CITY OF ALBUQUERQUE

**Re: Niche Bank Buildings & Parking
7999 Wyoming
30-Day Temporary Certificate of Occupancy
Transportation Development Final Inspection
Engineer's/Architect's Stamp dated 1-23-19 (D19D001A)**

ADMINISTRATIVE

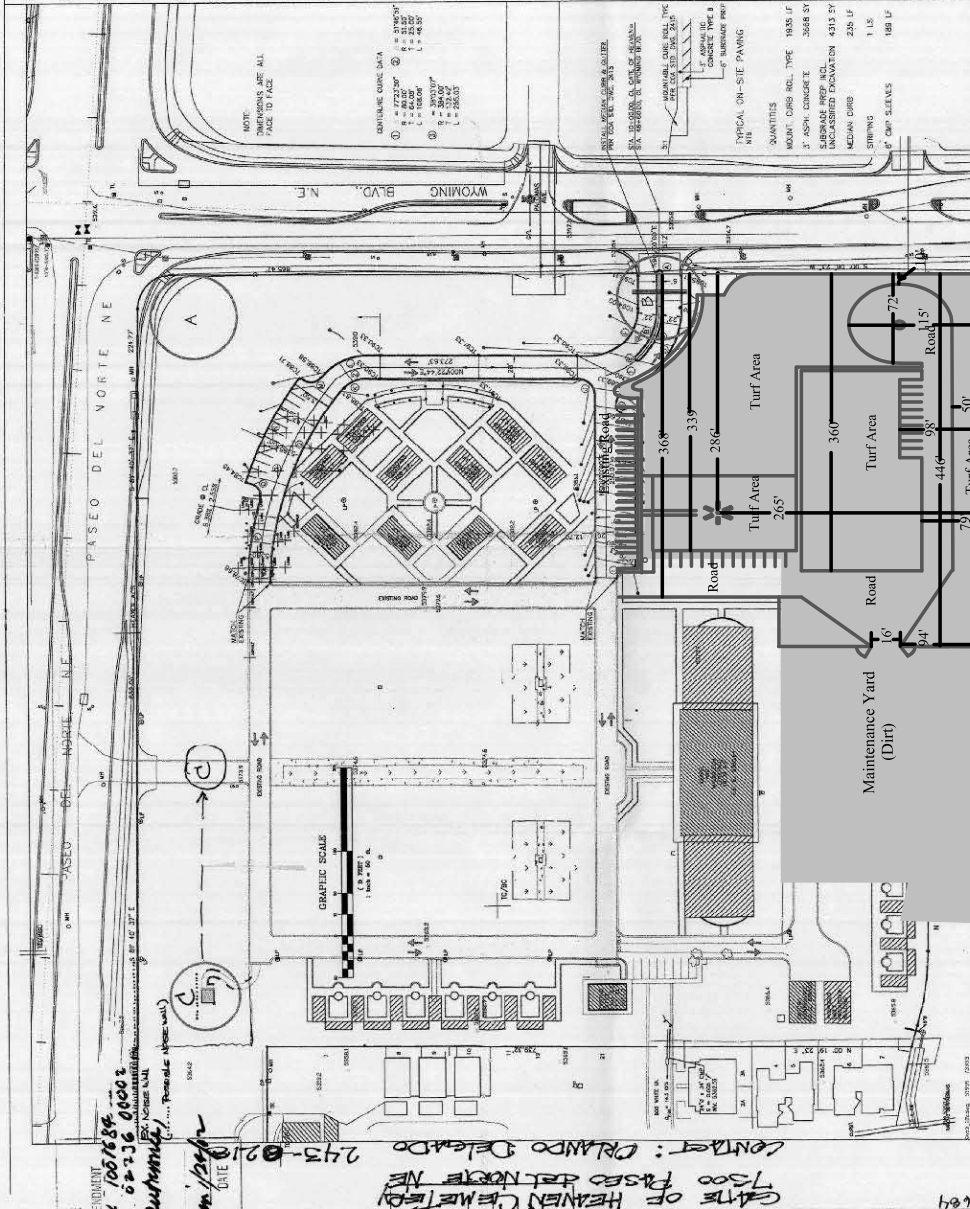
- Please add 2 ADA parking with access aisles. Please see attached ADA Details.
